KIRKLEES METROPOLITAN COUNCIL INVESTMENT & REGENERATION SERVICE

DELEGATED DECISION TO DETERMINE PLANNING APPLICATIONS

Reference No:	2021/62/94270/W
Site Address:	231, Fleminghouse Lane, Almondbury, Huddersfield, HD5 8TY
Description:	Erection of hip to gable front extension, side dormers, single storey canopy to front elevation and rear balcony and associated exterior alterations
Recommending Officer:	Tom Hunt

Officer Report

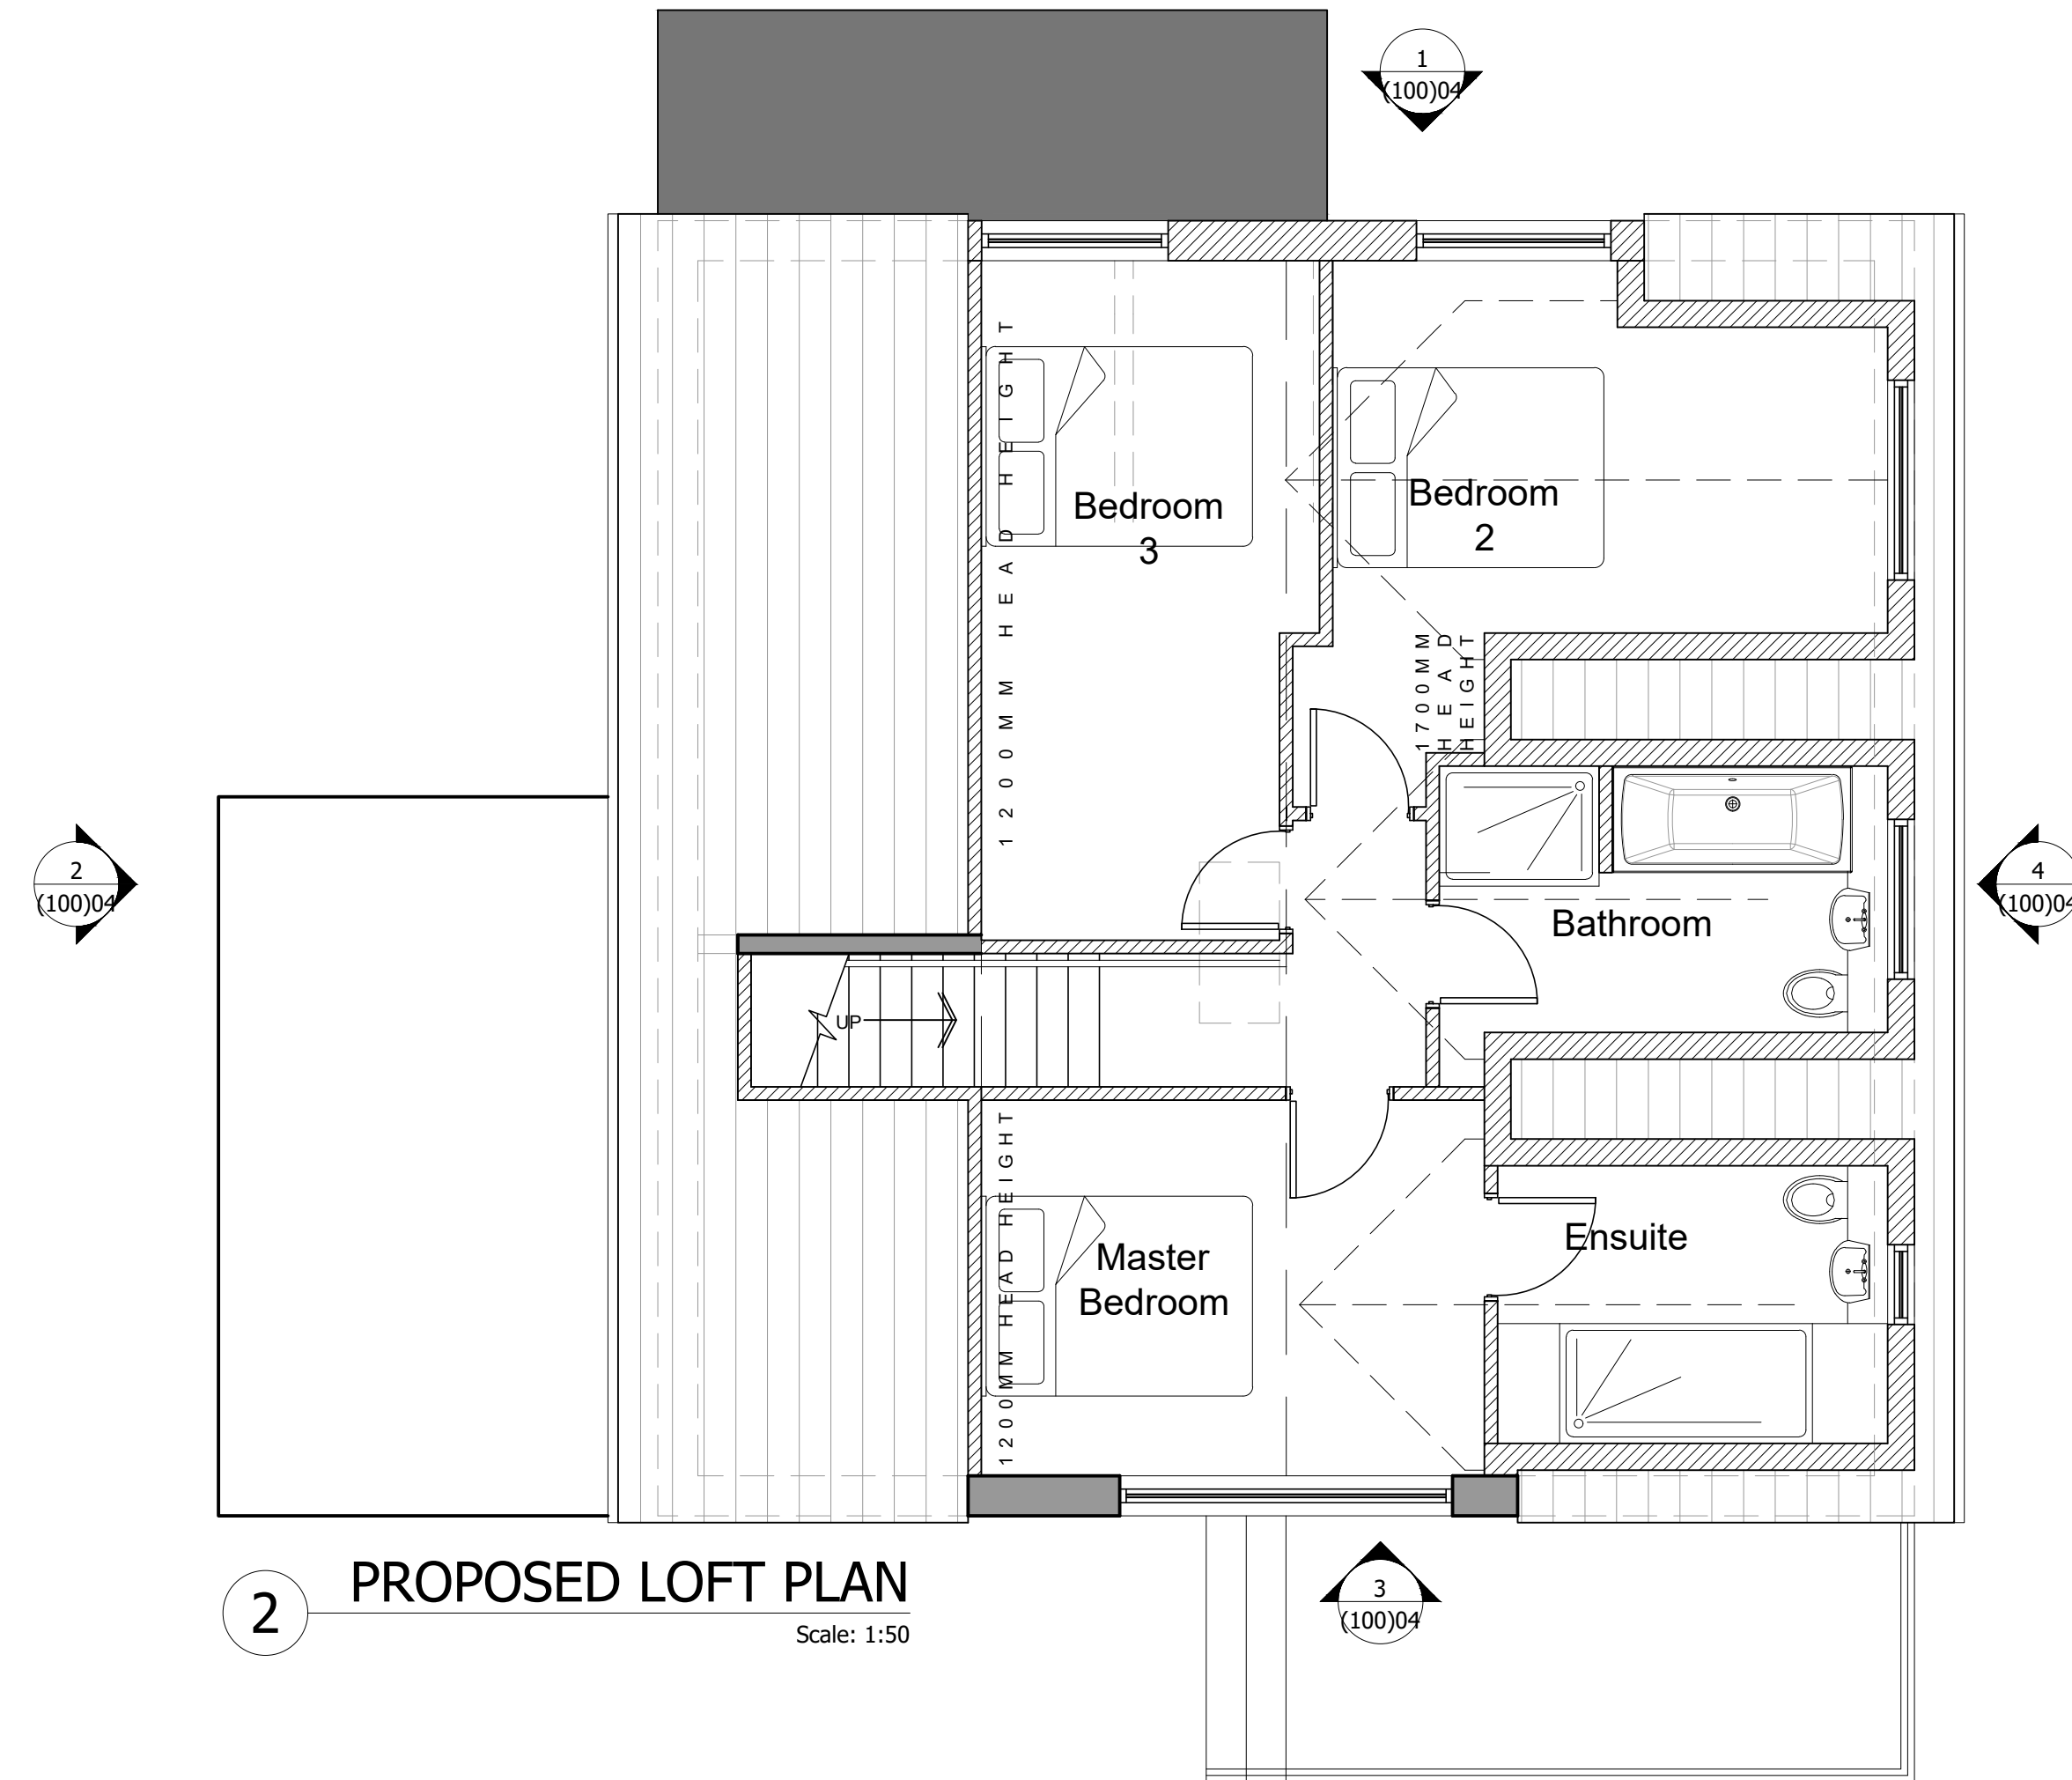
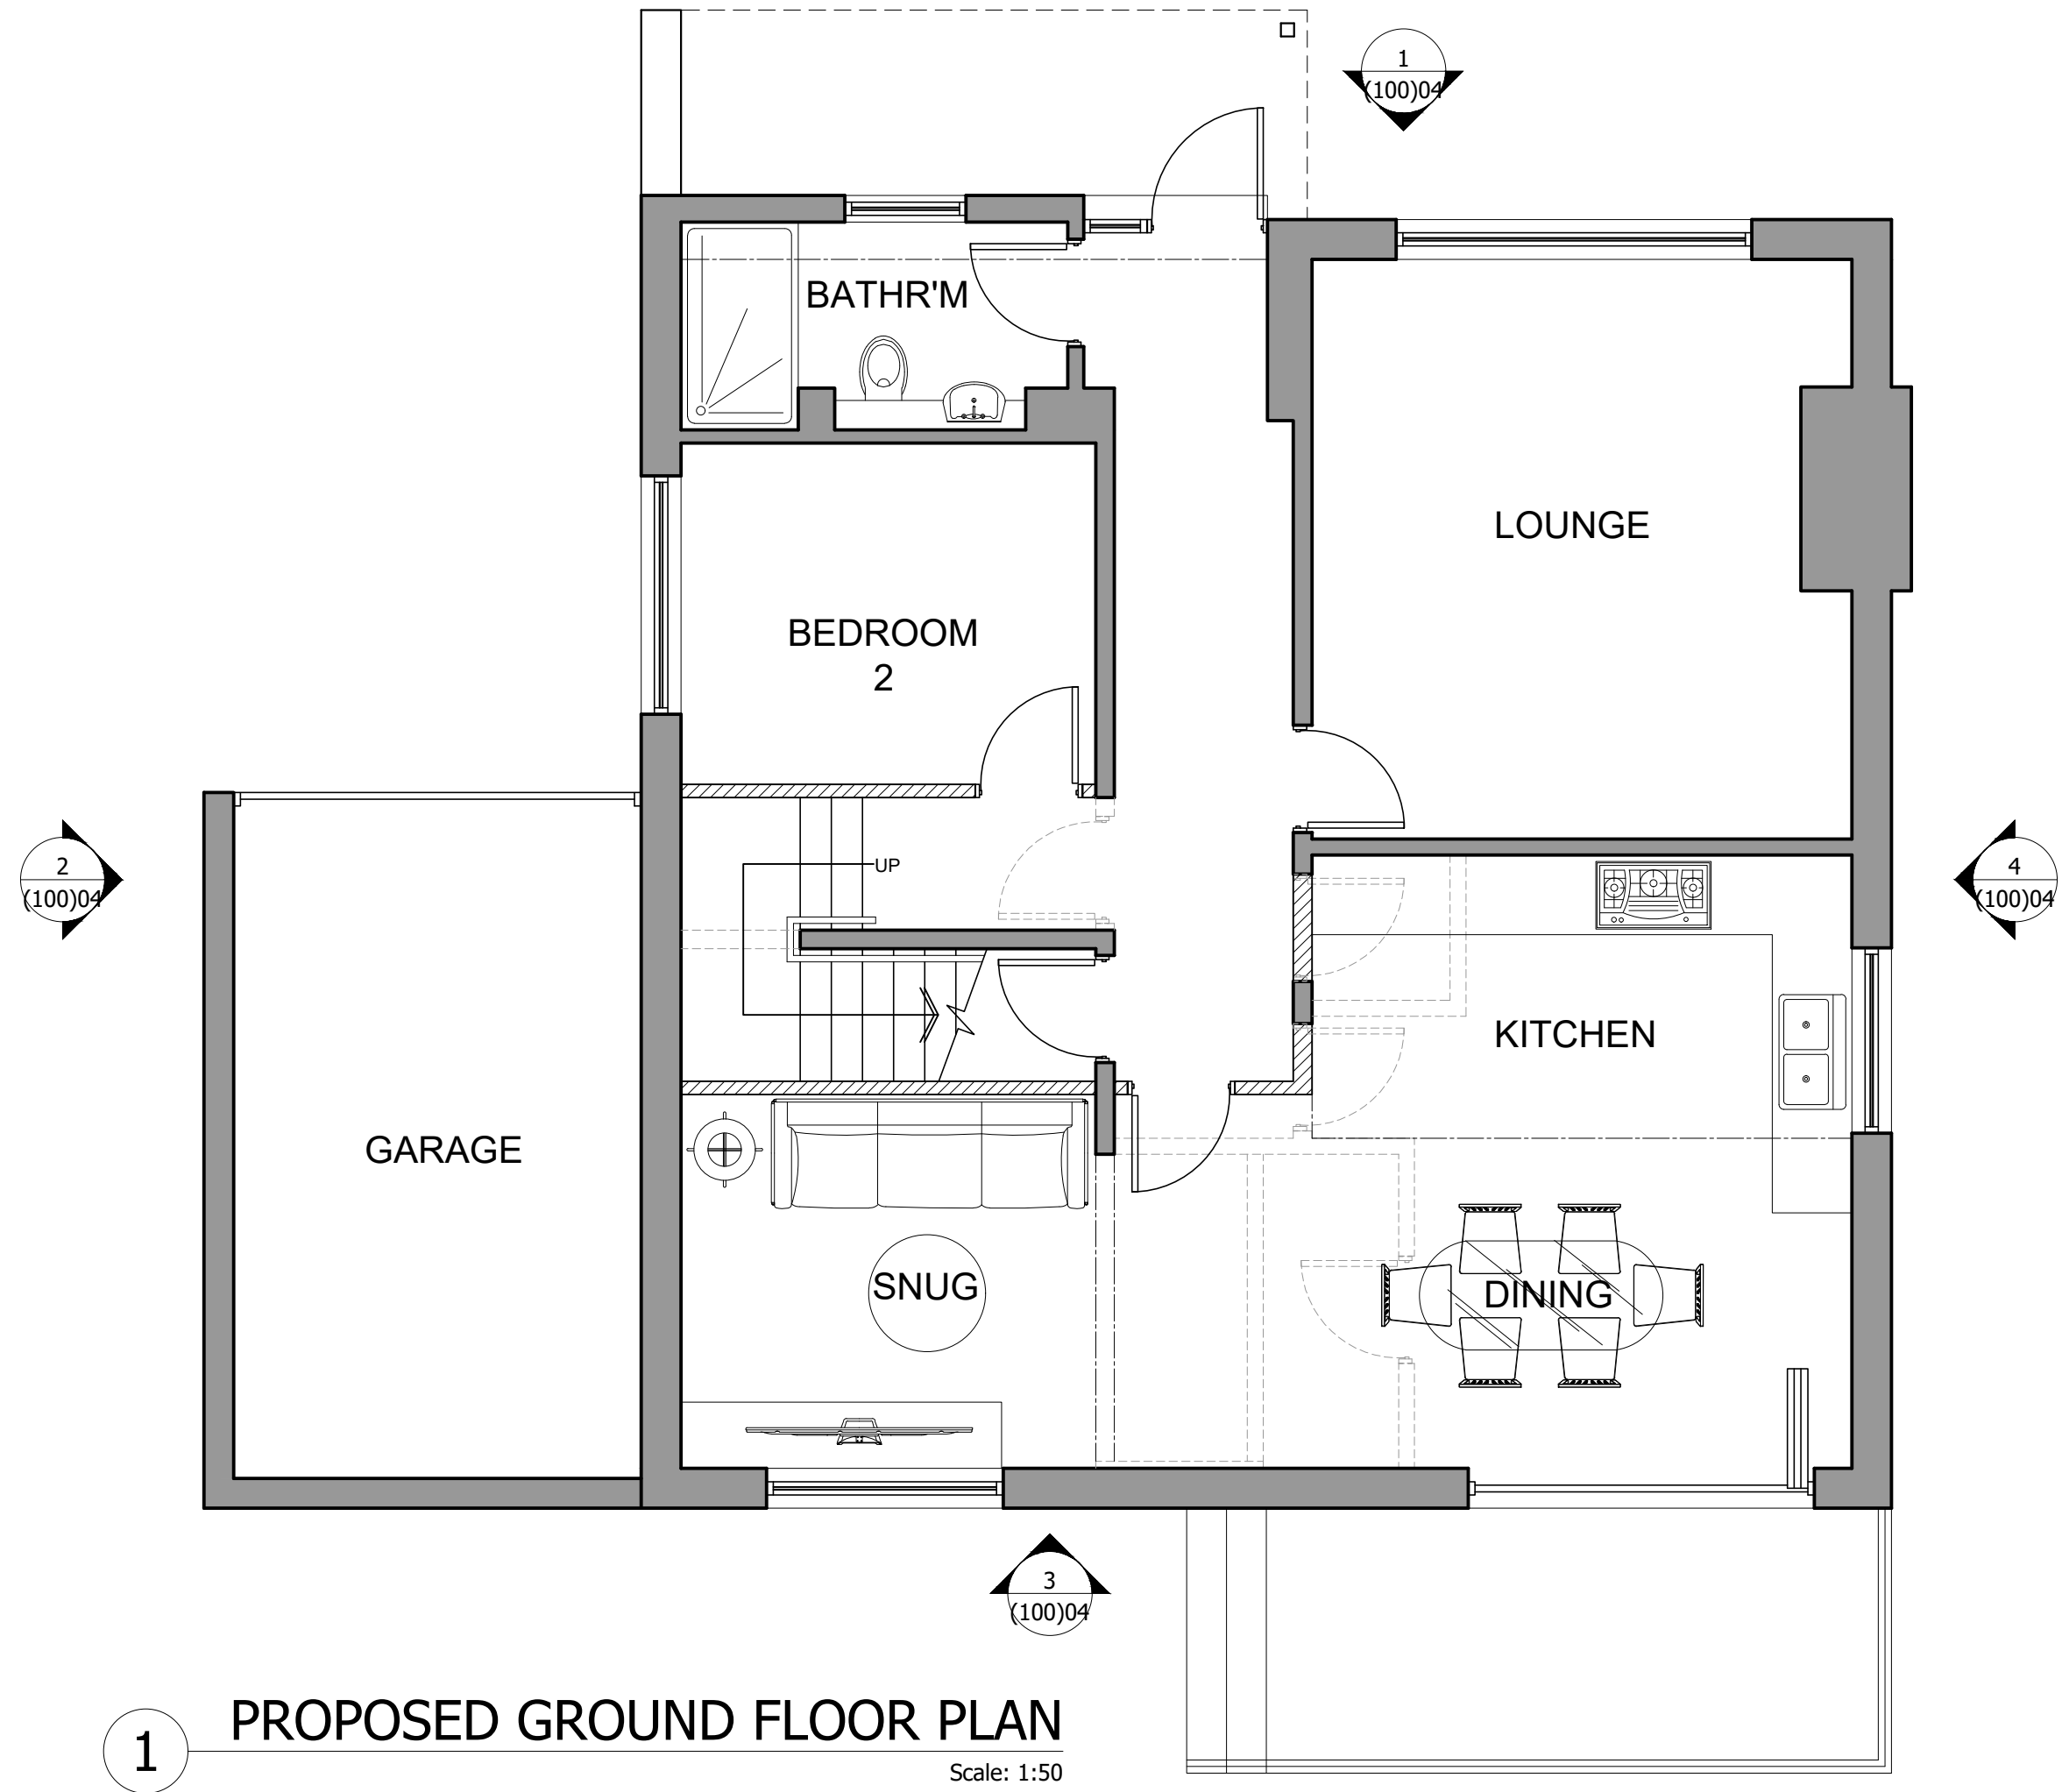
This would serve to add an extra floor of living space to be master bedroom and ensuite to rear, bathroom with staired access to middle and two bedrooms to the fore.

The ground floor would be re-configured to have a repositioned snug and extend the kitchen to be a kitchen dining room to the rear and to add stairs to the new roof accommodation.
